From: Bloomer, David <David.Bloomer@lancashire.gov.uk>
Sent: 30 March 2017 14:30
To: Adam Birkett
Cc: LHS Customer Service; planning
Subject: app3/2017/0080 Land Adj. former Genus Site , Whalley Road

Drawing Title  
Proposed Site Plan  
Phase 3 Commercial Units

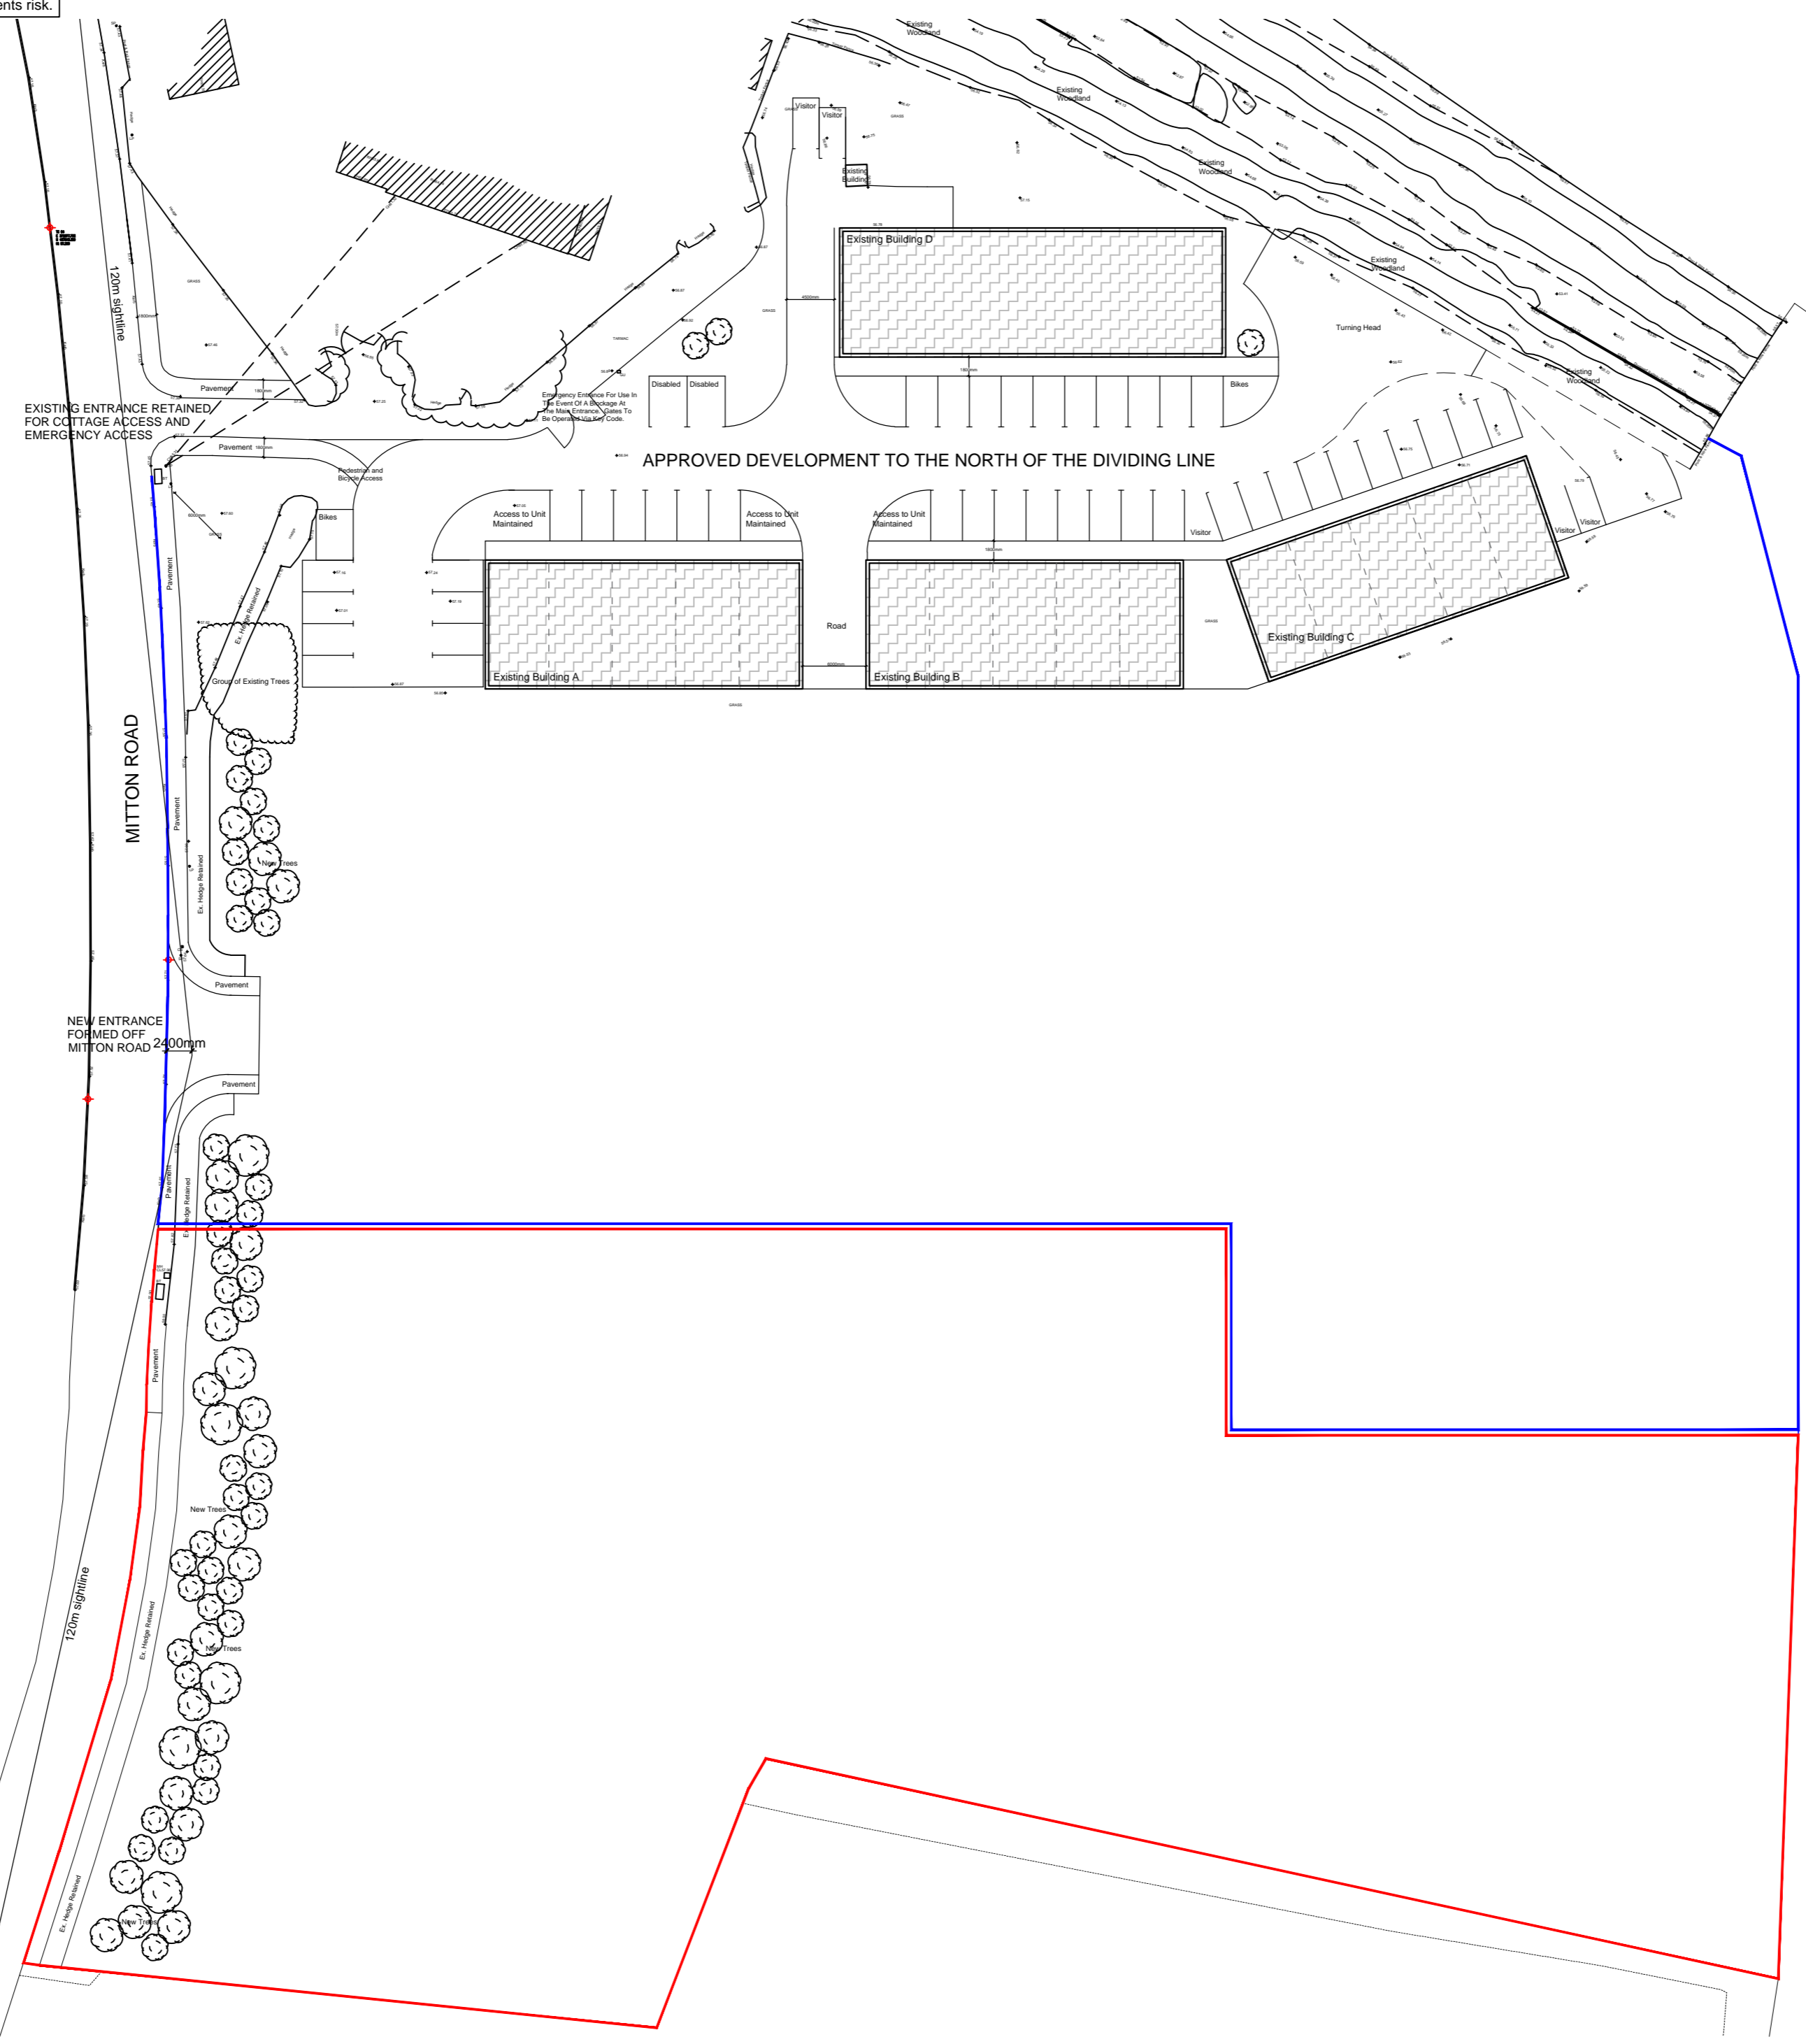
Apologies for the delay in my response. I note from the submitted plan that the intention would be to create a single point of access to the whole site with the existing access becoming redundant , albeit retained for access to the 2 dwellings and as an emergency//pedestrian /cycle access to the site. On this basis I would raise no objection to the proposal on highway grounds but would request that the following conditions be attached to any permission that may be granted

2 The existing access shall be physically and permanently closed at its junction with the internal estate road except for emergency situations. Provision shall be retained for the unobstructed passage of pedestrians and cyclists concurrent with the formation of the new access/within Reason: To limit the number of access points to, and to maintain the proper construction of the highway.
